CITY OF ALBUQUERQUE

**Re: O'Reilly Auto Parts
12700 Lomas NE
Request Permanent C.O. - Accepted
Engineer's Stamp dated: 1/28/2016 (K22D019)
Certification dated: 9-8-16**

**Re: O'Reilly Auto Parts
12700 Lomas Blvd NE
Request 60-Day Temporary C.O. – Accepted
Engineer's Stamp dated: 1/28/2016 (K22D019)
Certification dated: 9-8-16**

Based on the Certification received 9/8/2016, the above referenced is approved for a 60-day Temporary Release of Occupancy by Hydrology. However, before a permanent CO can be accepted the following comments must be addressed.

## 4 STANDARD DRAWING 2236 - DRAINAGE SIDEWALK CULVERT WITH STEEL PLATE TOP

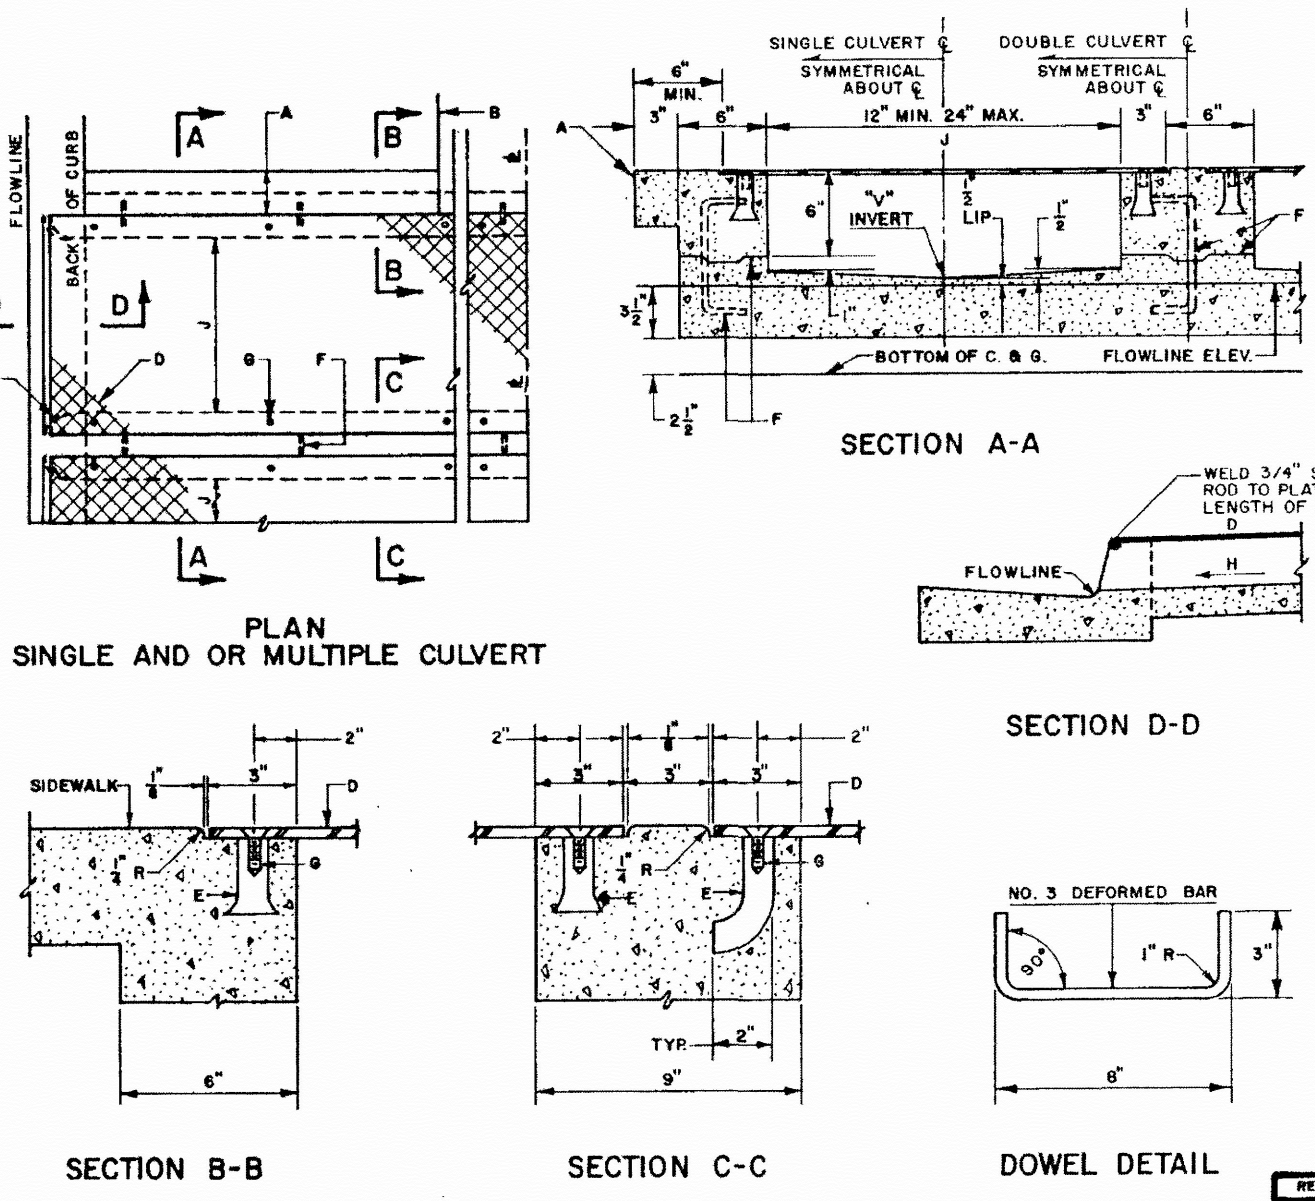
| PO Box 1293 | • The plate on the sidewalk culvert at the curb end is past the face. It needs to be shortened flush with the curb or preferably shorter as to not damage the tires of a parked vehicle. |
| Albuquerque | • Two bolts are missing on the S/W culvert. At least four of the bolts need to be tack-welded. |
| | • There is no expansion material on both sides of the culvert. It can be saw cut and filled with NP-1 sealant. |
